**SSD-9887 – West Nowra Resource Recovery Facility Stage 2 – Advice on EIS  
Bioelektra Australia Pty Ltd**

I am writing in reply to your invitation to the Environment Protection Authority (EPA) to provide advice on the Environmental Impact Statement (EIS) prepared by GHD for Bioelektra Australia Pty Ltd (Proponent) in relation to the new resource recovery facility at West Nowra (project).

The EPA has reviewed the EIS and the accompanying attachments provided by the Department of Planning, Industry and Environment (DPIE) and provides comments in Attachment 1. The EPA comments relate to a range of odour, water and contaminated land issues.

1 PROPOSED GROUND FLOOR PLAN
1: 250

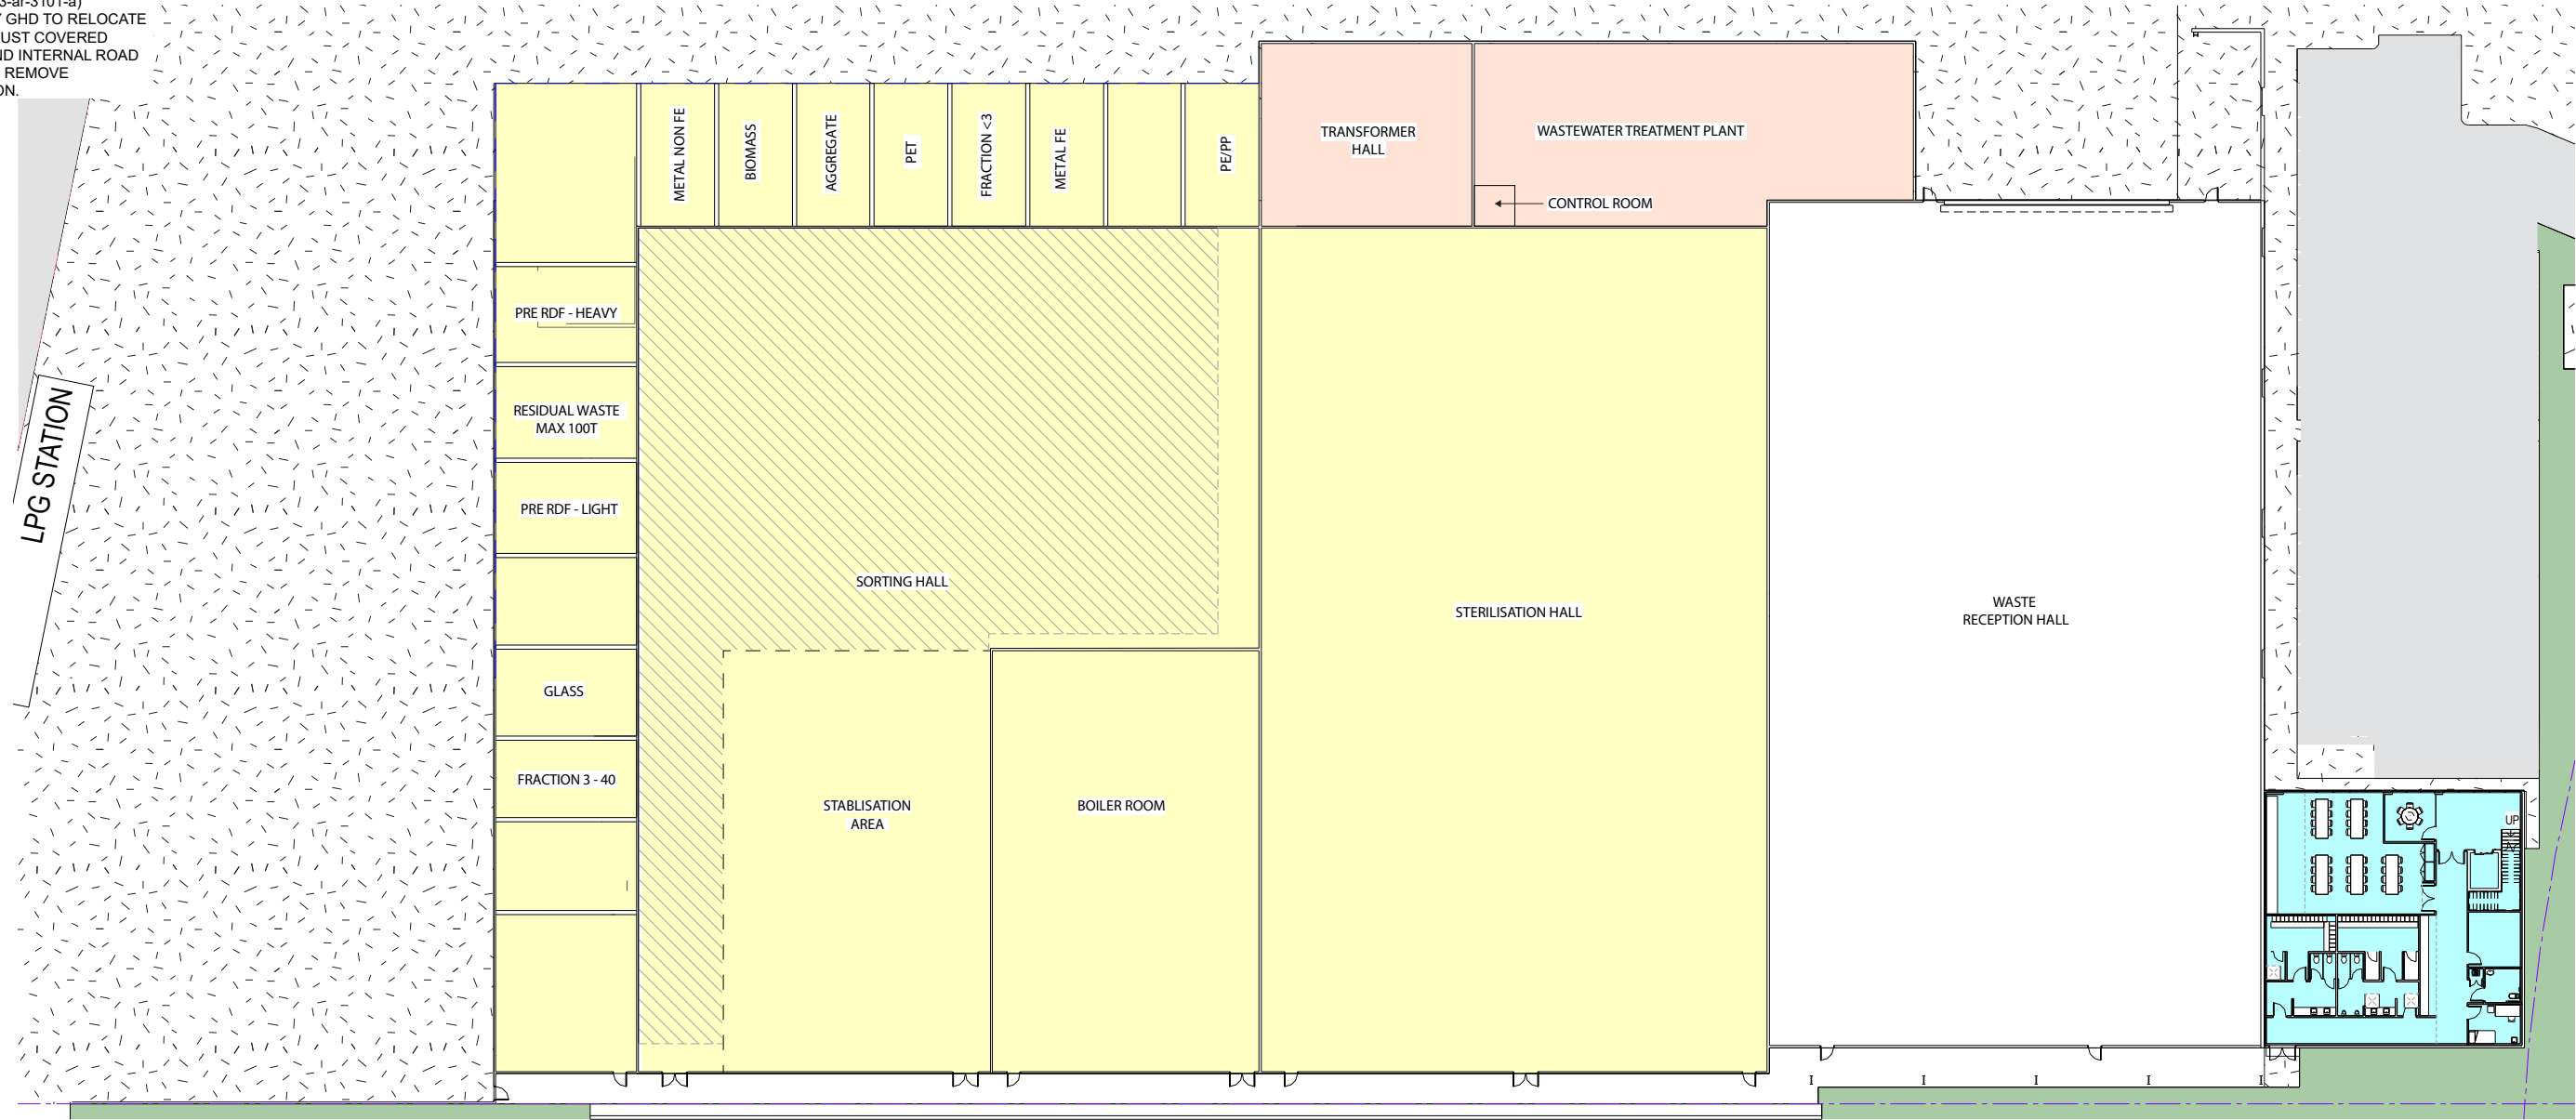
***It is noted that the roller doors are along the wall closest to Receptor R11, at a distance of 55m, which is very close. The Proponent should comment on the appropriateness of having the roller door so close to R11, and whether the configuration can be redesigned to minimise impacts to R11.***

FIGURE 6-1

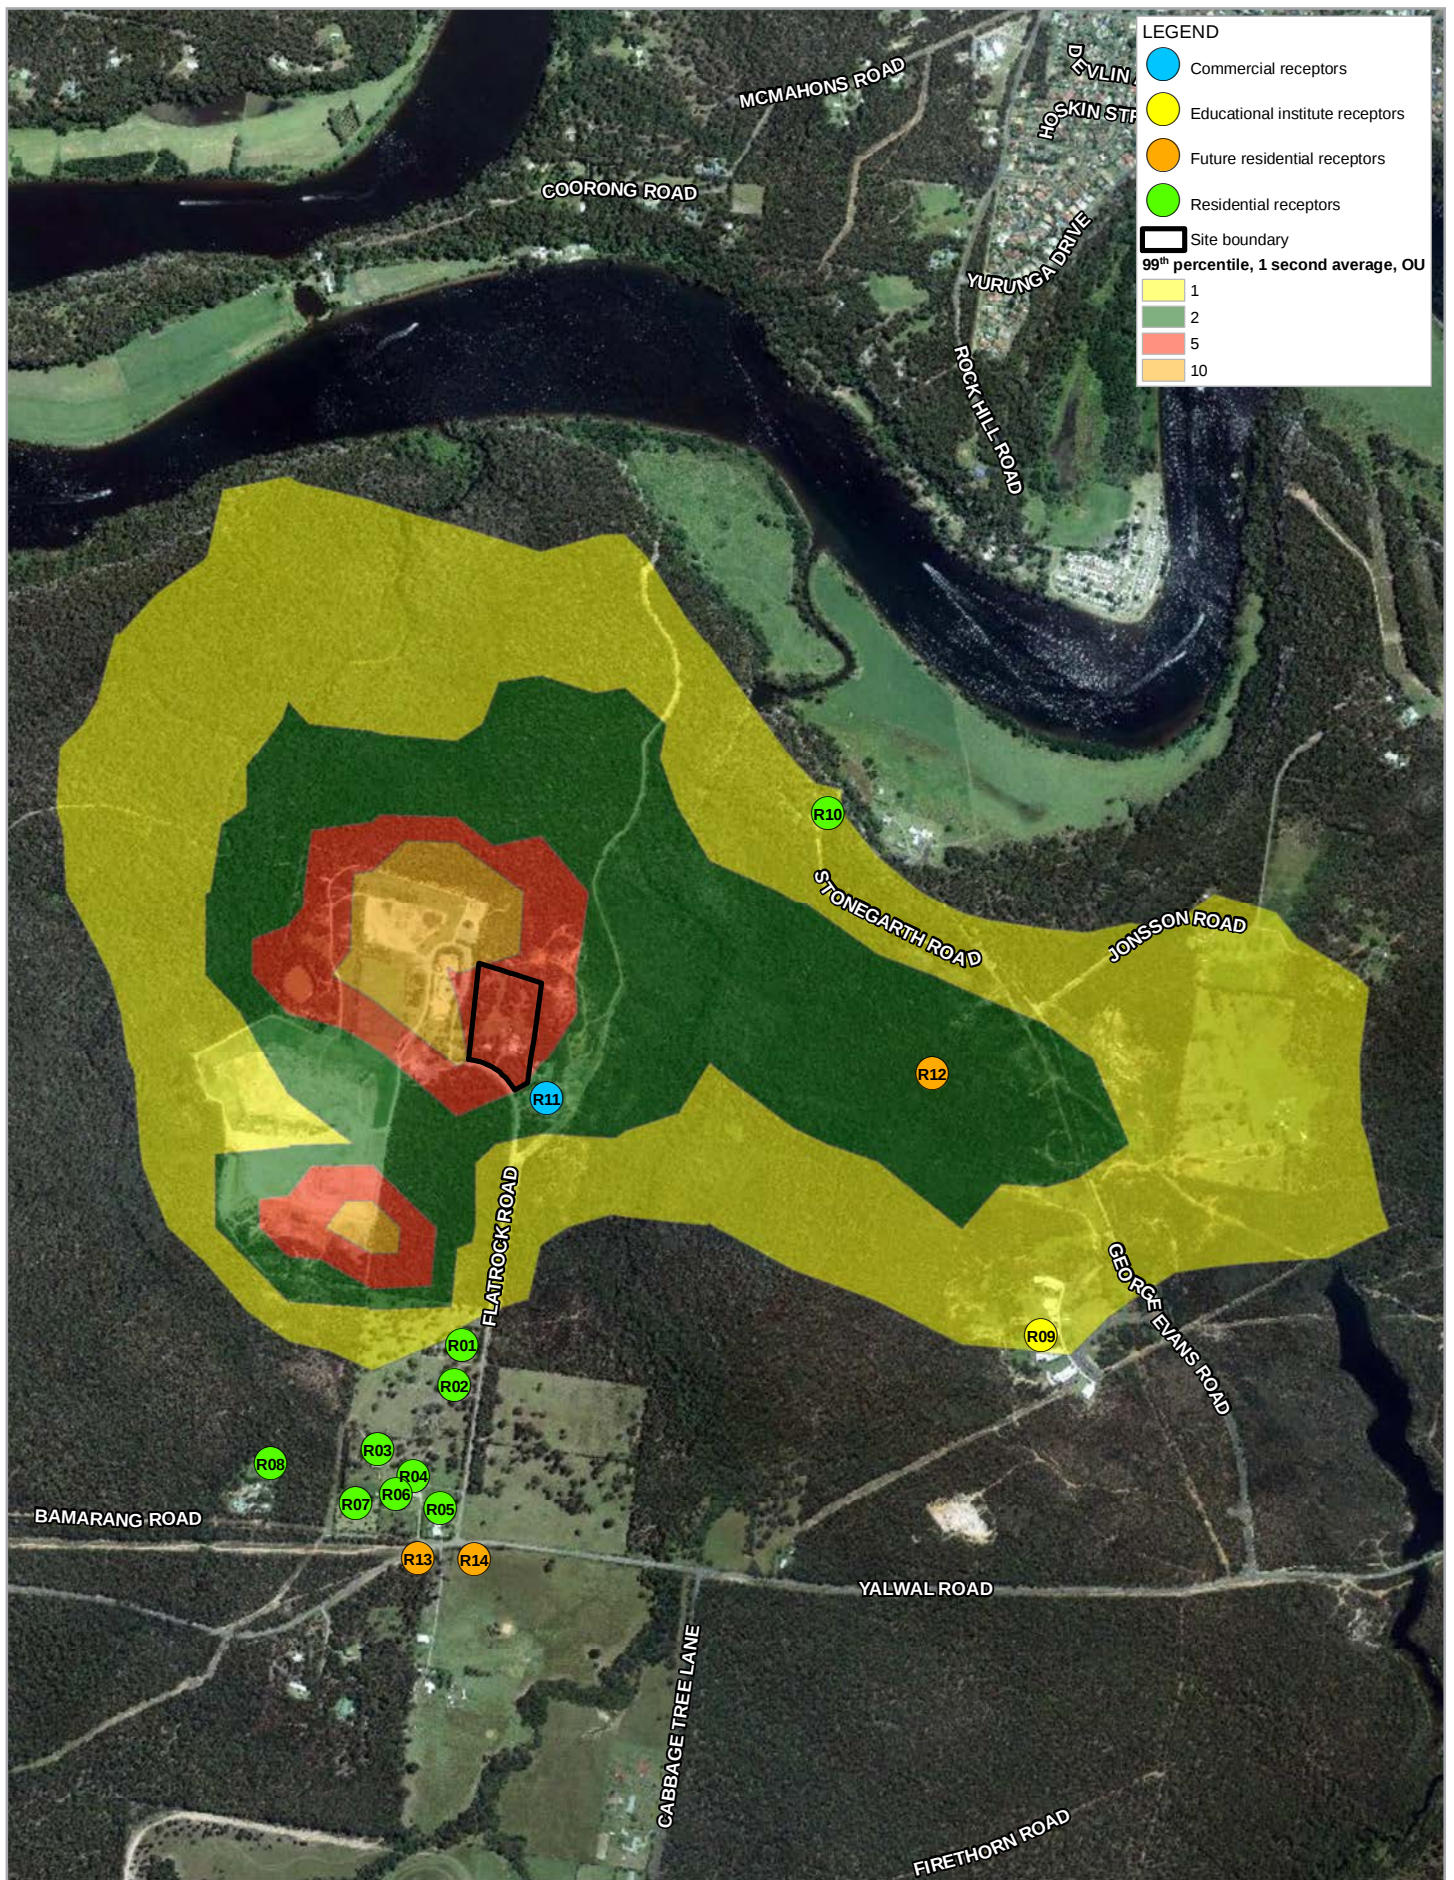
The proposal assumes that there are fugitive emissions from the doorway at a velocity of 0.1 m/s. The velocity is unjustified, and the modelling should include a sensitivity analysis of the effect of this parameter on modelling results, specifically regarding impacts on R11.

The proposal assumes the fugitive emissions occur 25% of the time, and therefore the emissions are multiplied by 25%. This is an error. The fugitive emissions, when they occur, will be 100% of the doorway emissions, and thus modelled emissions in the current proposal are underestimated. Since it is unknown when roller doors are open or not between 6am and 6pm, modelling should assume doorway emissions occur at all delivery hours.

***The modelling should be revised to:***

- a) Include a sensitivity analysis of the velocity in the doorway on the impacts at R11.***
- b) demonstrate that predicted impacts meet the criterion, using the corrected emission rate. If an exceedance is predicted, additional controls should be nominated.***
